14 August 2019

The Manager
Department of Planning Industry & Environment
GPO Box 39
SYDNEY NSW 2001

SSD-5012 MOD 1 – PROPOSED EXTRACTIVE INDUSTRY – ATLAS-CAMPASPE MINERAL SANDS, OPTIMISATION OF MINING AND RAIL LOADING, IVANHOE-BALRANALD ROAD, BALRANALD.

TRONOX
 OPTIMISATION MODIFICATION
 Modified Ivanhoe Rail Facility
 General Arrangement

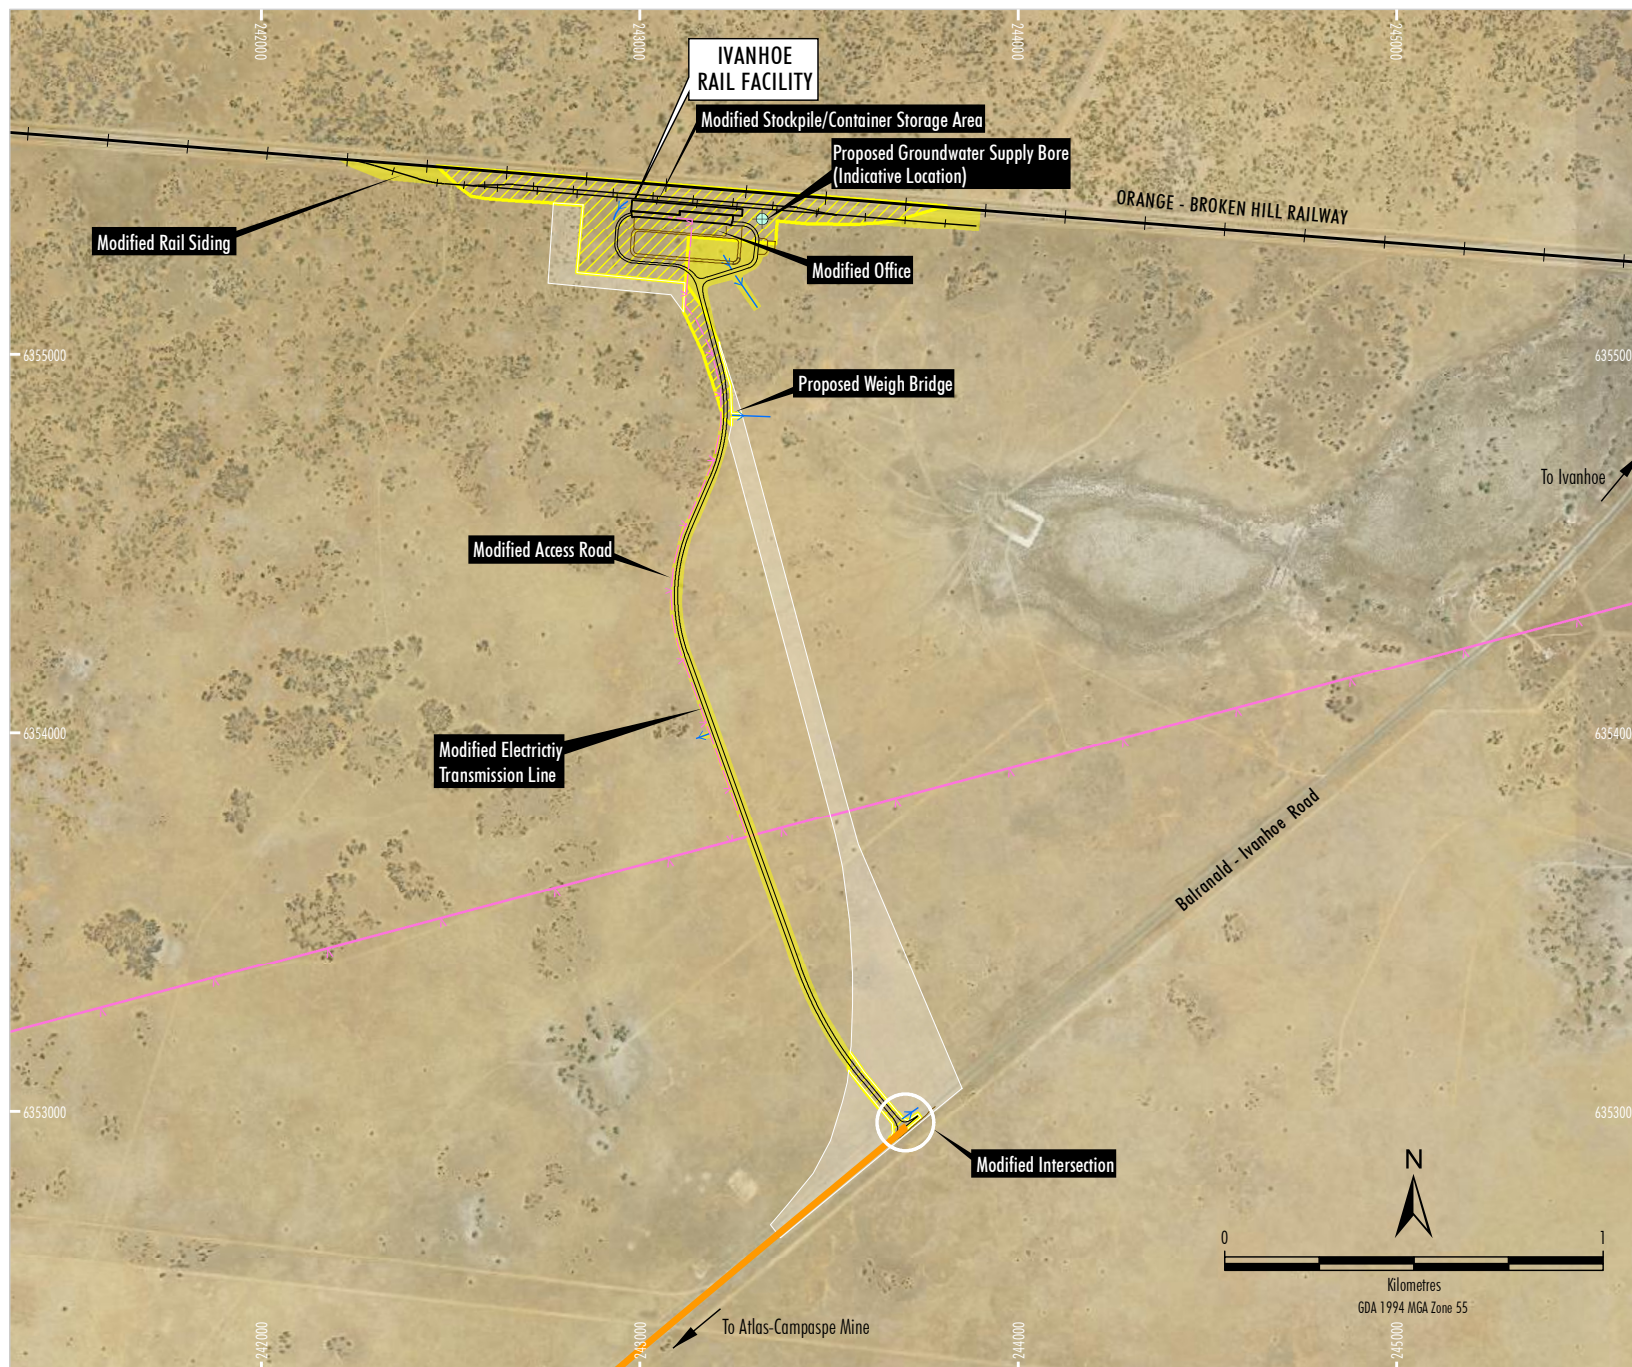
The intersection for the rail facility access road with the Balranald-Ivanhoe Road is proposed to be modified to provide for a Basic Right Turn (BAR)/Basic Left Turn (BAL) intersection treatment. Based on the direction of travel and the traffic volumes on the Balranald-Ivanhoe Road Roads and Maritime would not object to this modification subject to the intersection treatment being designed and constructed in accordance with the Austroads Guide to Road Design for the posted speed limit for an approved road train route. The rail facility access road shall be sealed for at least 100 metres from the carriageway of the Balranald-Ivanhoe Road.

TRONOX
OPTIMISATION MODIFICATION
Project Light Vehicle Access Routes

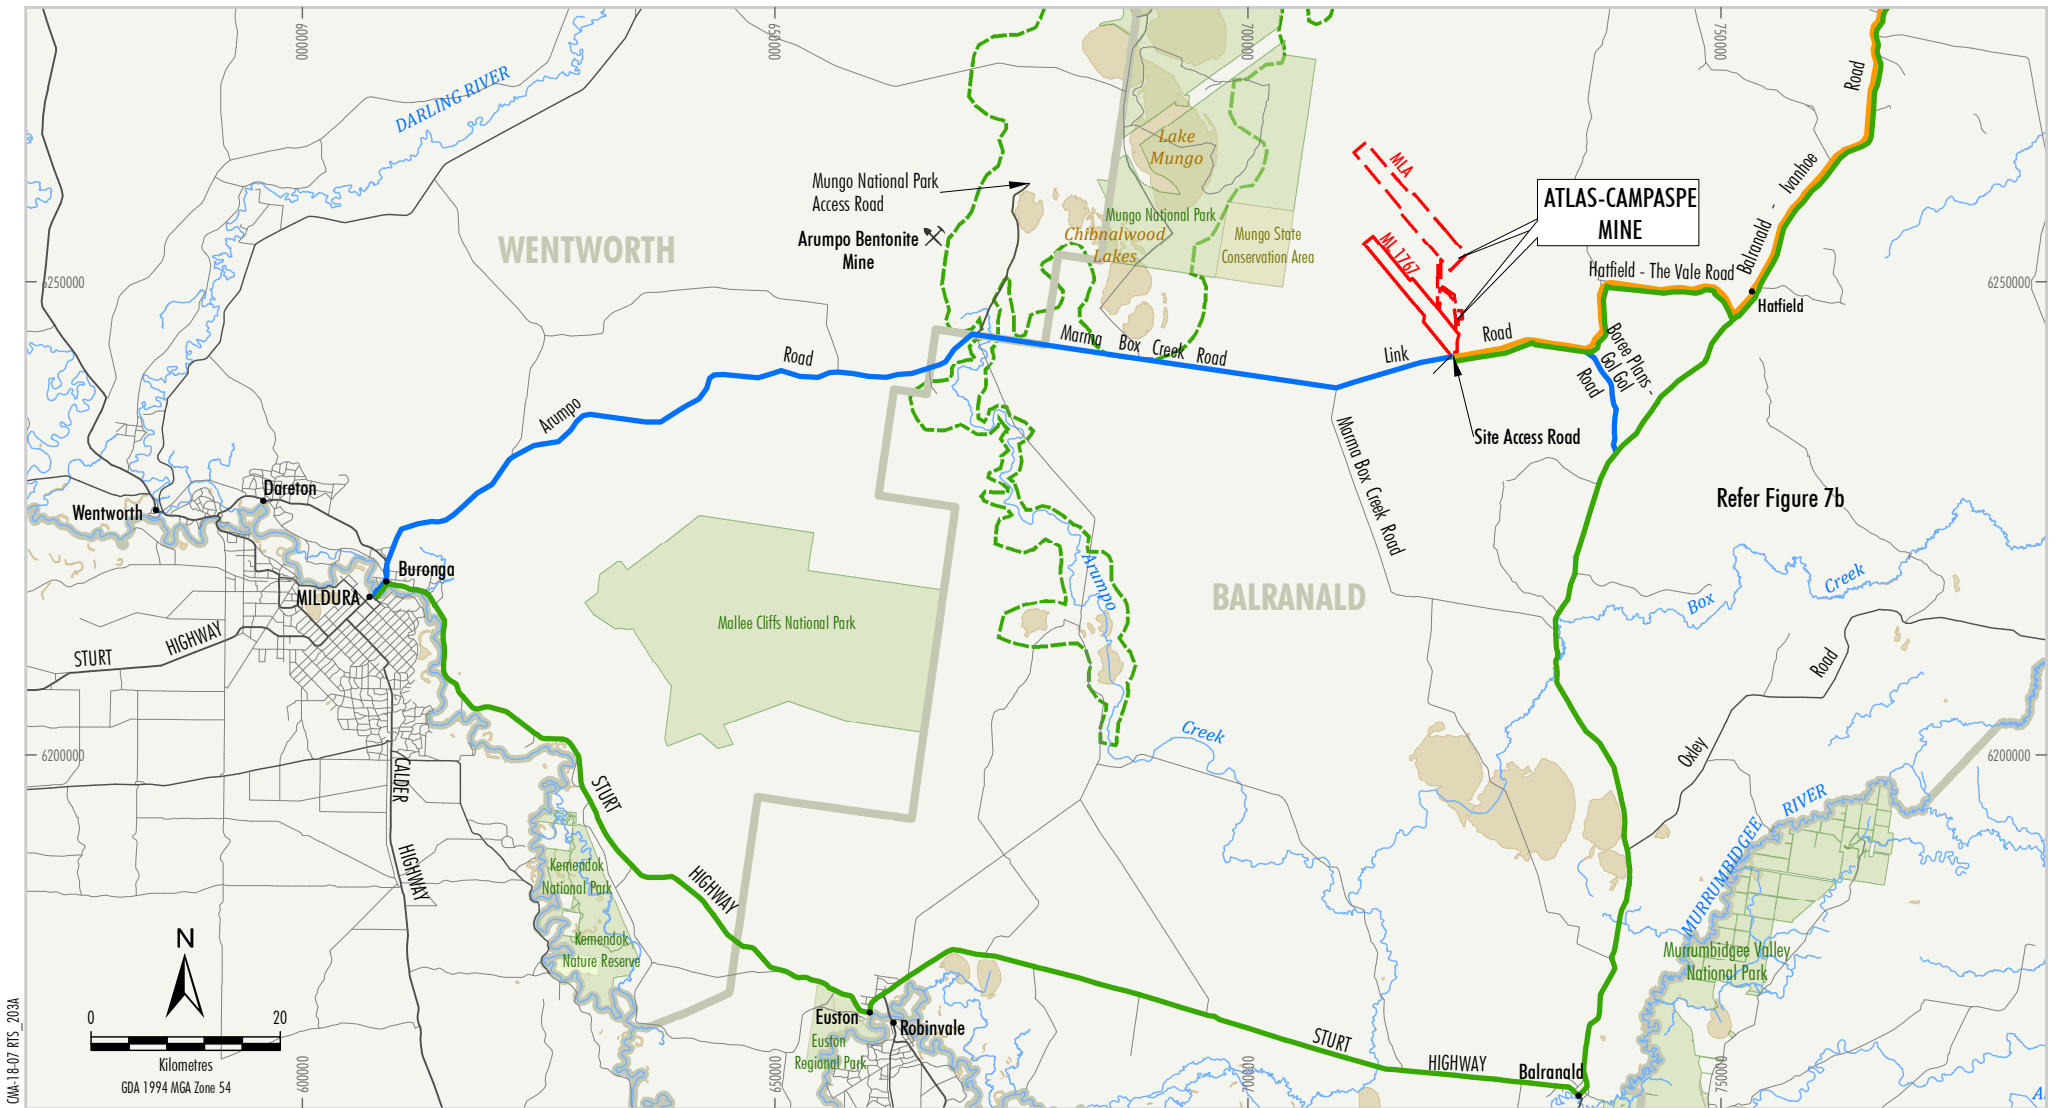
This modification to Condition 6 is proposed for light vehicles only and should be conditioned to deny heavy vehicles and shall require the preparation of management plan to provide for a regular regime of inspection of suitability and road maintenance along the route for road safety purposes. The management plan is to be developed in association with, and approved by, the Balranald and Wentworth Shire Councils. A management plan to address fatigue management for workers travelling to and from the mine site shall be prepared to the satisfaction of Council and Roads and Maritime Services. The Road Transport Assessment recommends that the revised Transport Management Plan (CMA, 2018a) would include a revised Fatigue Management Plan prepared in consideration of the Fatigue Management Guide (NSW Resources Regulator, 2018) and incorporates specific measures for the Project workforce.

The modified proposal also includes the use of Boree Plains-Gol Gol Road to the Balranald-Ivanhoe Road instead of using the Mine access road to its intersection with the Balranald-Ivanhoe Road. This represents a reduction in travel distance of approximately 32 km. Over 12 months of operations of the Project, it is estimated that this represents a saving of over 0.4 million vehicle kilometres travelled (VKT). This revised route will require works to the intersection of the Boree Plains-Gol Gol Road with the Balranald-Ivanhoe Road. The Road Transport Assessment acknowledges the need for works to this intersection. The intersection is to be constructed to provide for a Basic Right Turn (BAR)/Basic Left Turn (BAL) intersection treatment in accordance with the Austroads Guide to Road Design for the posted speed limit for an approved road train route. The Boree Plains-Gol Gol Road shall be sealed for at least 100 metres from the carriageway of the Balranald-Ivanhoe Road. Schedule 3 Condition 1 table 1: Road Upgrade Works should be modified to refer to works to upgrade the existing Balranald-Ivanhoe Road and Boree Plains-Gol Gol Road intersection. The reference to Boree Plains-Gol Gol Road (5.5 km section) may also need to be modified as the intention is to use this road to its intersection with Balranald-Ivanhoe Road.
